Add:
File Number: AL2411

Application for Special Use Permit for Metal Barn Construction

The property address is 17625 Person Dr., Peyton, CO 80831. The property tax schedule number is 4124005006. Legal Description is Lot 1 Crocker Sub No3. The parcel is zoned A-5 and is not subject to overlay zoning.

New Ag Bldg.

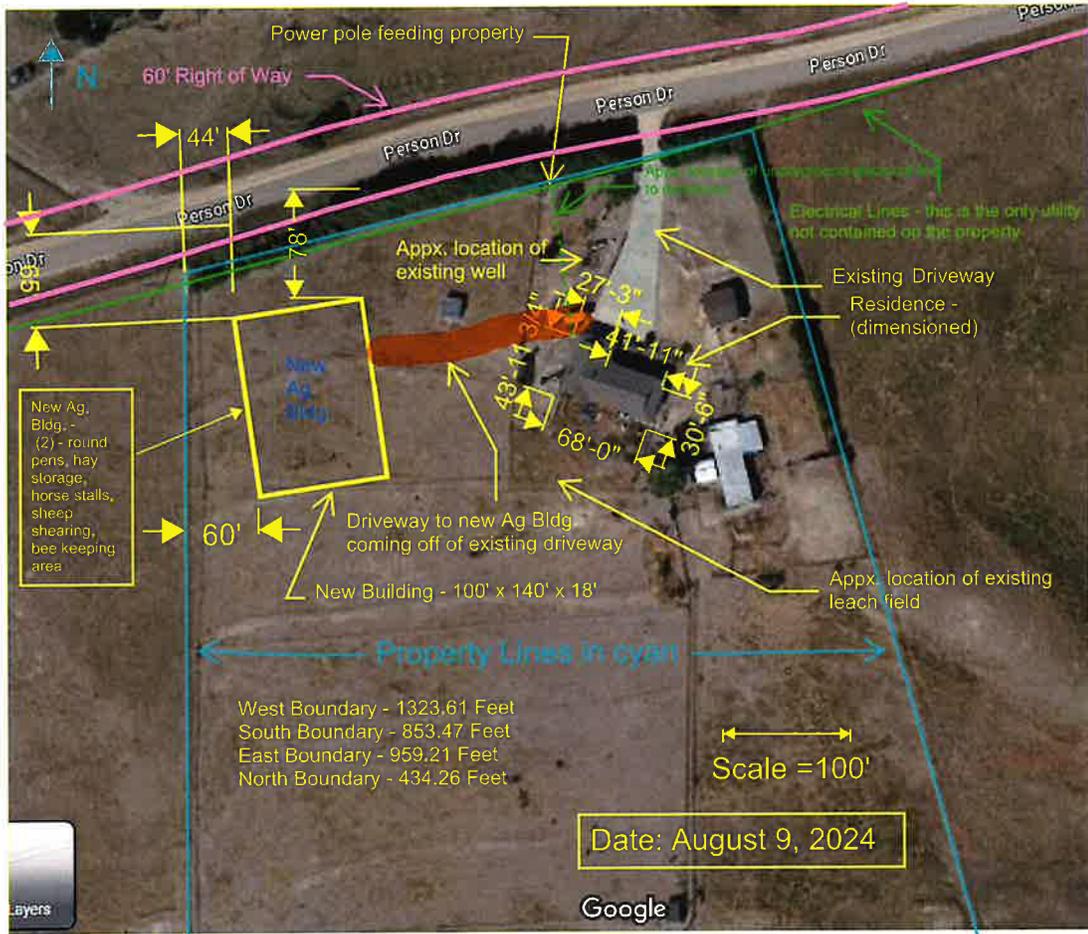
Please discuss and state that "the structure will not have adverse stormwater drainage impacts to downstream or adjacent properties."
